Engineers Comments Regarding Condition 7

Application No: P/154/21/DOC
Registered: 8th November 2021
Site Address: Land South of Summer Lane and West of Pagham Road Pagham
Description of Works: Approval of details reserved by condition imposed under ref P/140/16/OUT relating to Condition Nos 7 - landscaping & layout and 9 - Arboricultural Method Statement & Tree Protection Plan.

Drawing No.	Rev.
D1915-301	C

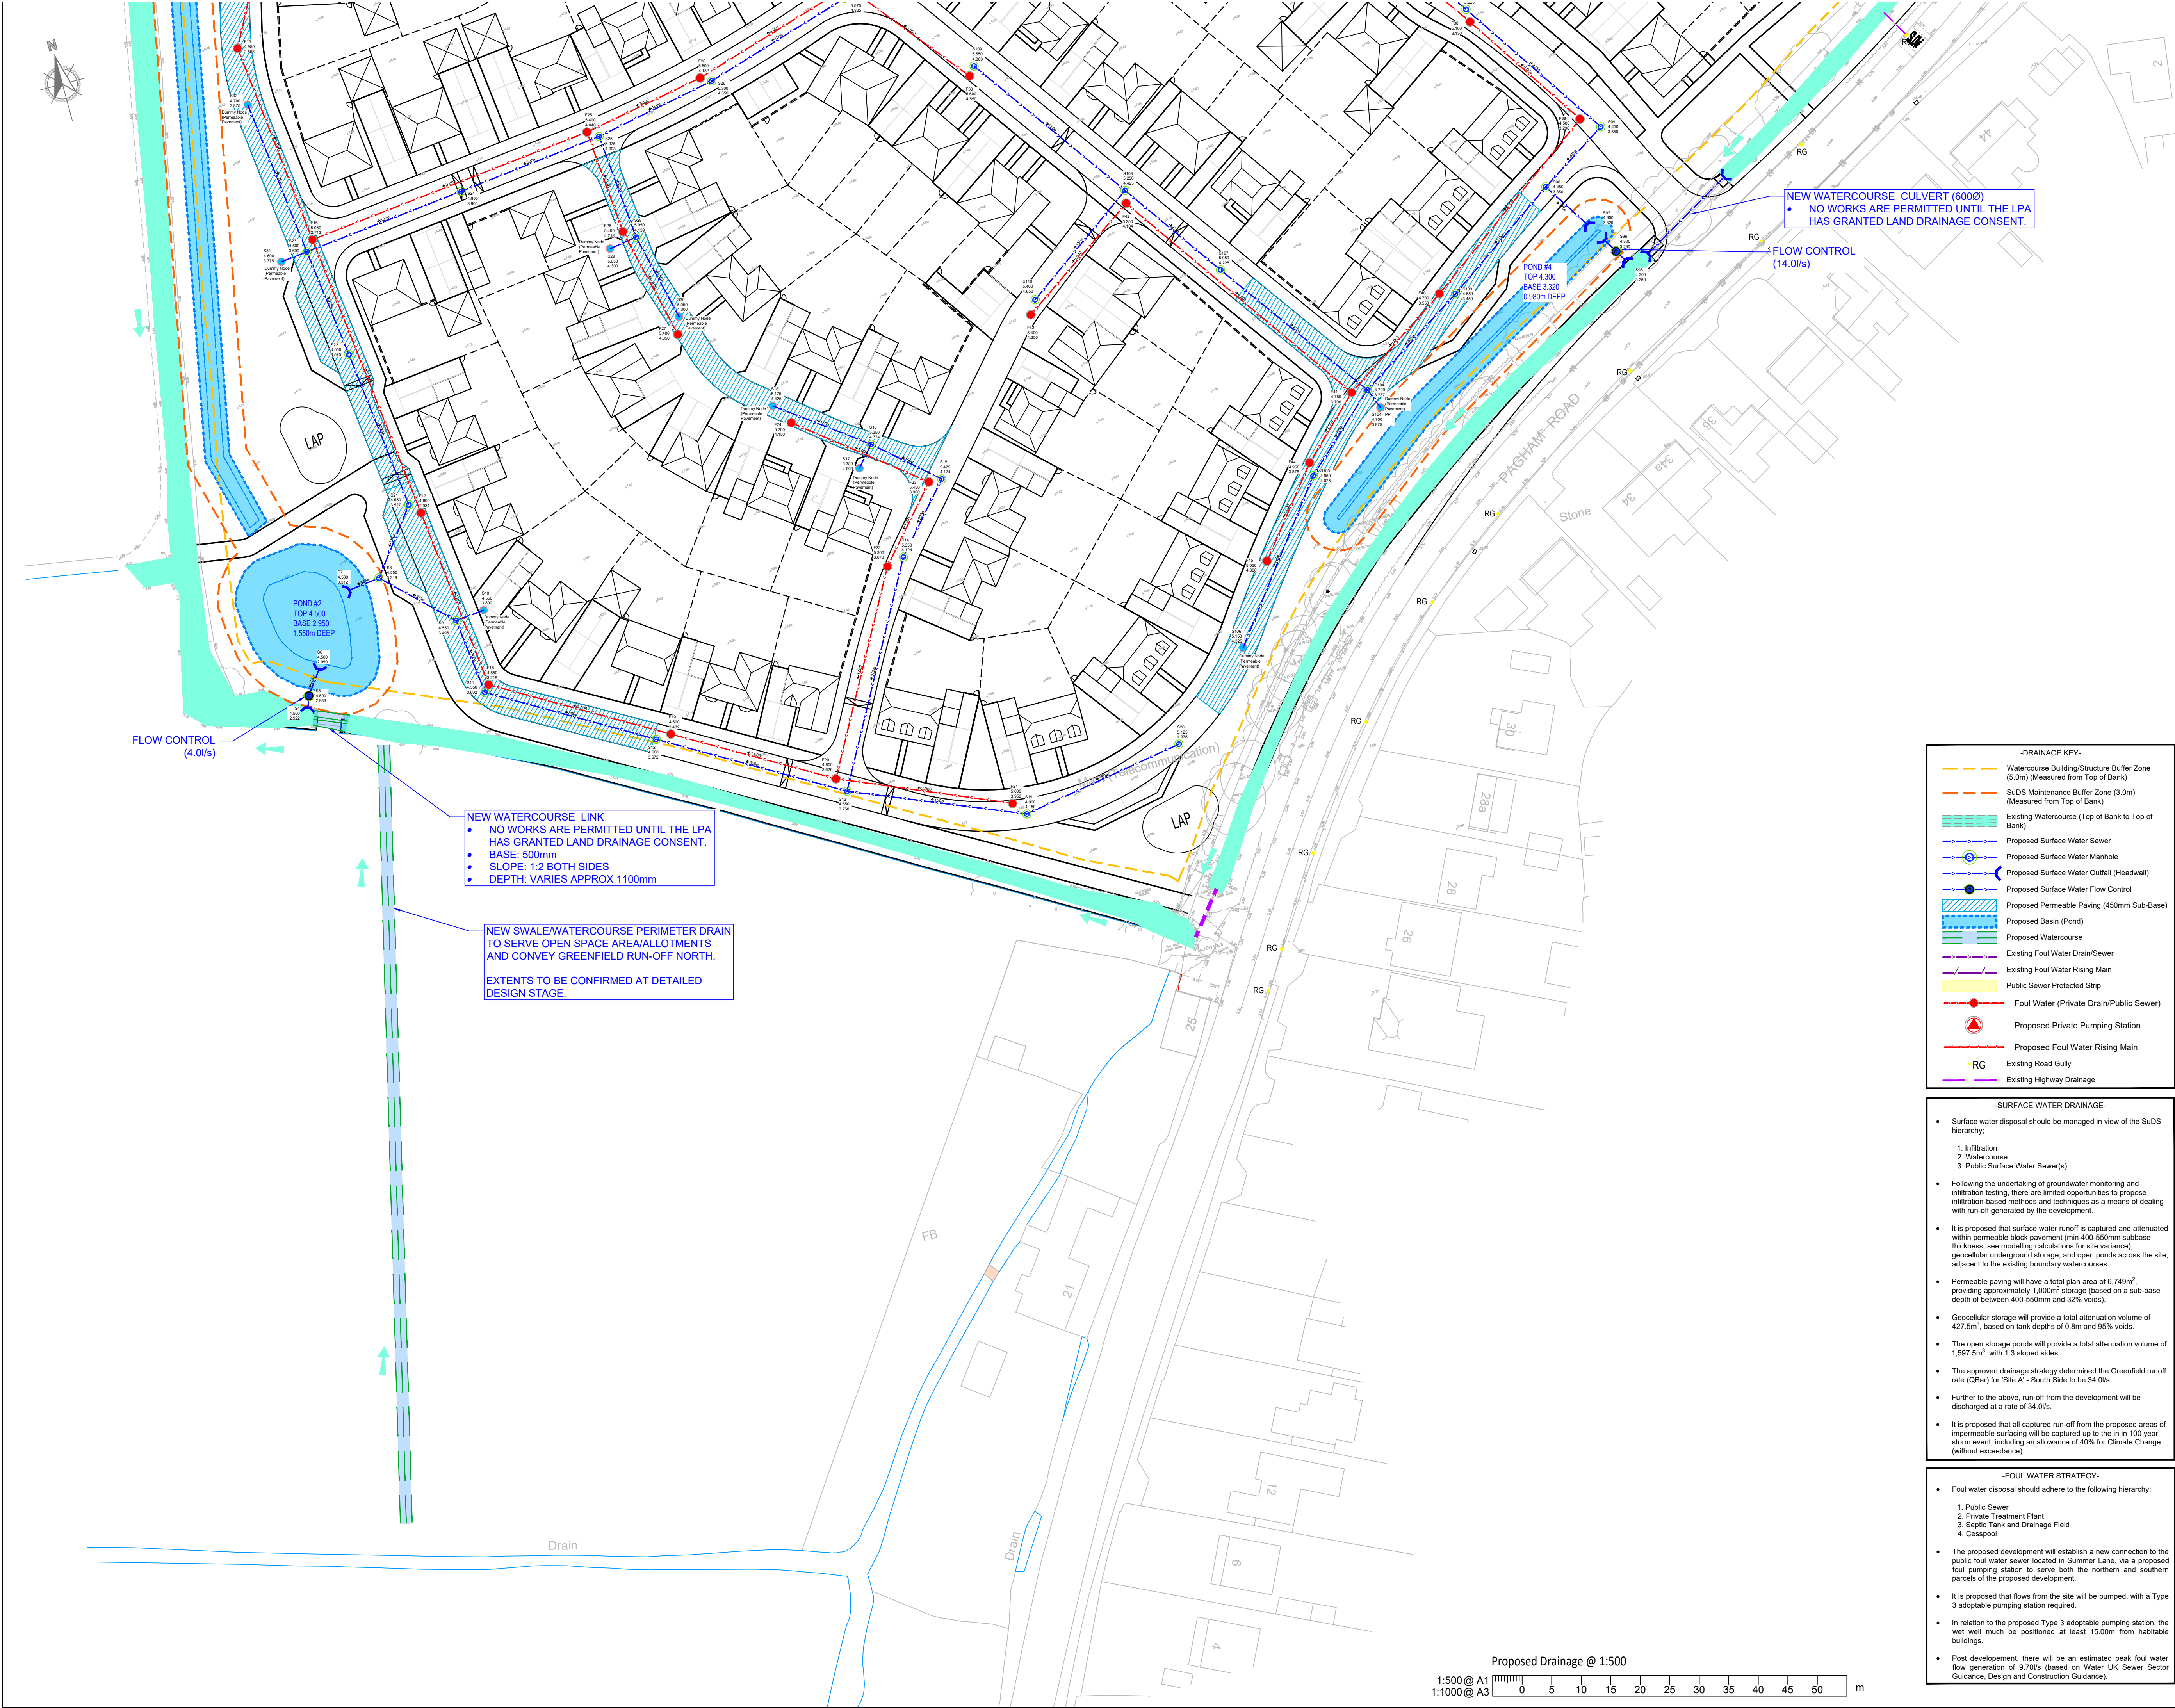
A number of trees are proposed in close proximity to surface water drainage features. Root potential areas must not conflict with surface water drainage features. There are considerable issues with the surface water drainage as currently proposed, we therefore do not recommend that condition 7 is discharged at this time.
